PLANNING CONSULTATION RESPONSE

Application No	2025/0920
Proposal	Demolition of existing side single storey extension and garage; erection of two storey side; rear single storey extensions; front entrance porch and detached double garage with alterations to driveway and parking arrangements.
Address	St Johns Close, 379 Carlton Road, Carlton, Barnsley, S71 3JB.
Date of Consultation Reply	23/04/2026
Consultee	Edward Jowett (Tree Officer)

FRONT ELEVATION

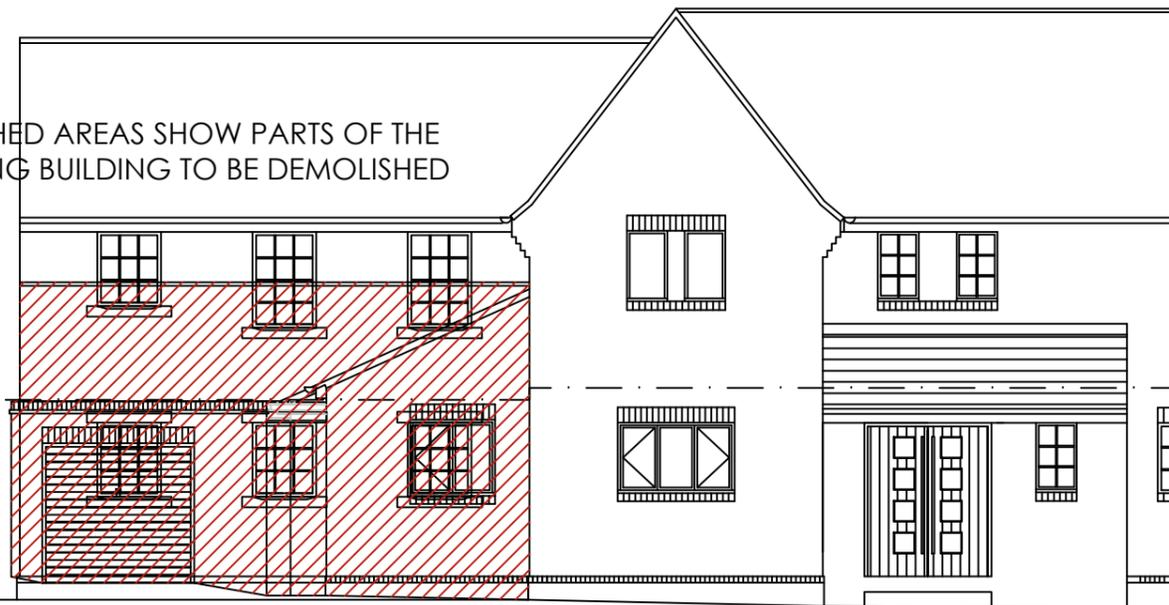
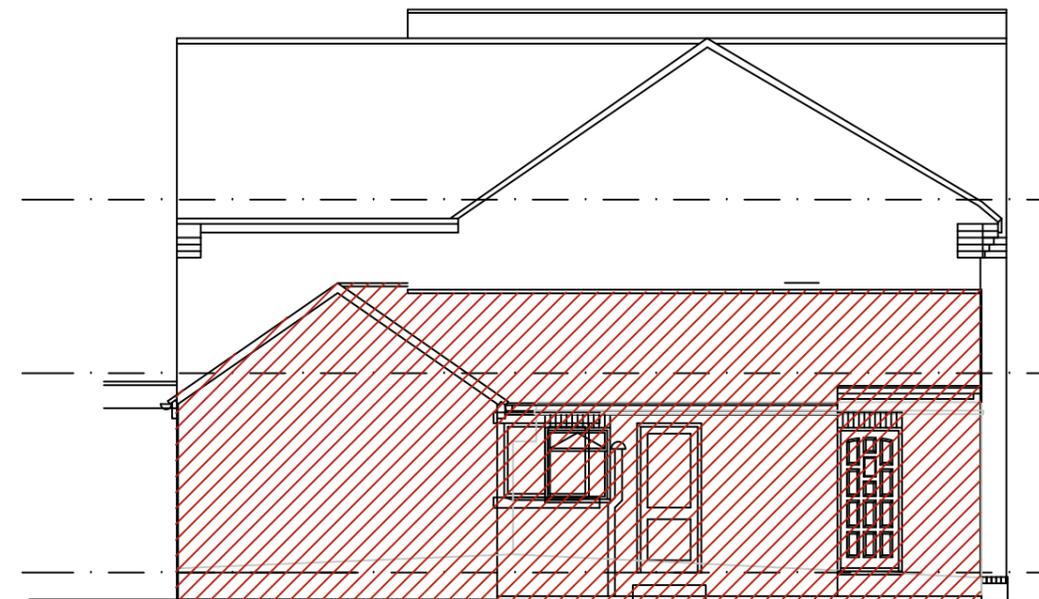
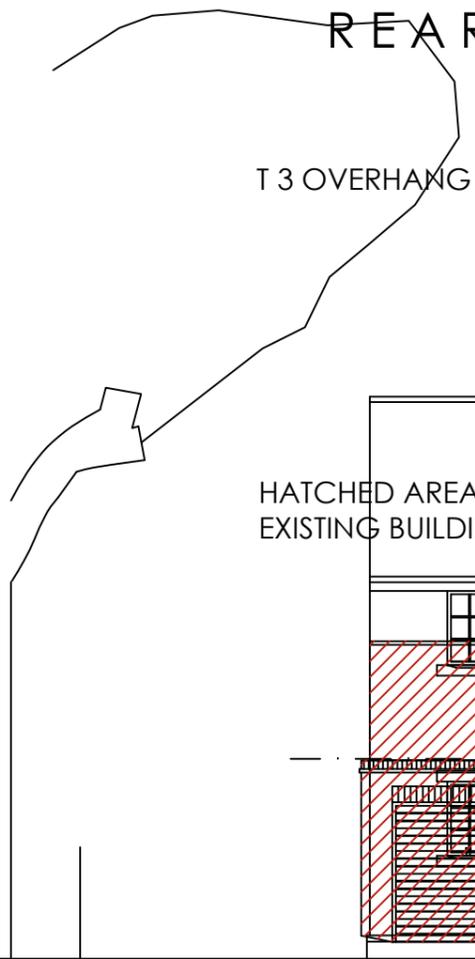
Further to my previous comments a plan had been provided to demonstrate that no works are required to T3 to facilitate the construction of the extension and that there is satisfactory clearance between it and the tree.
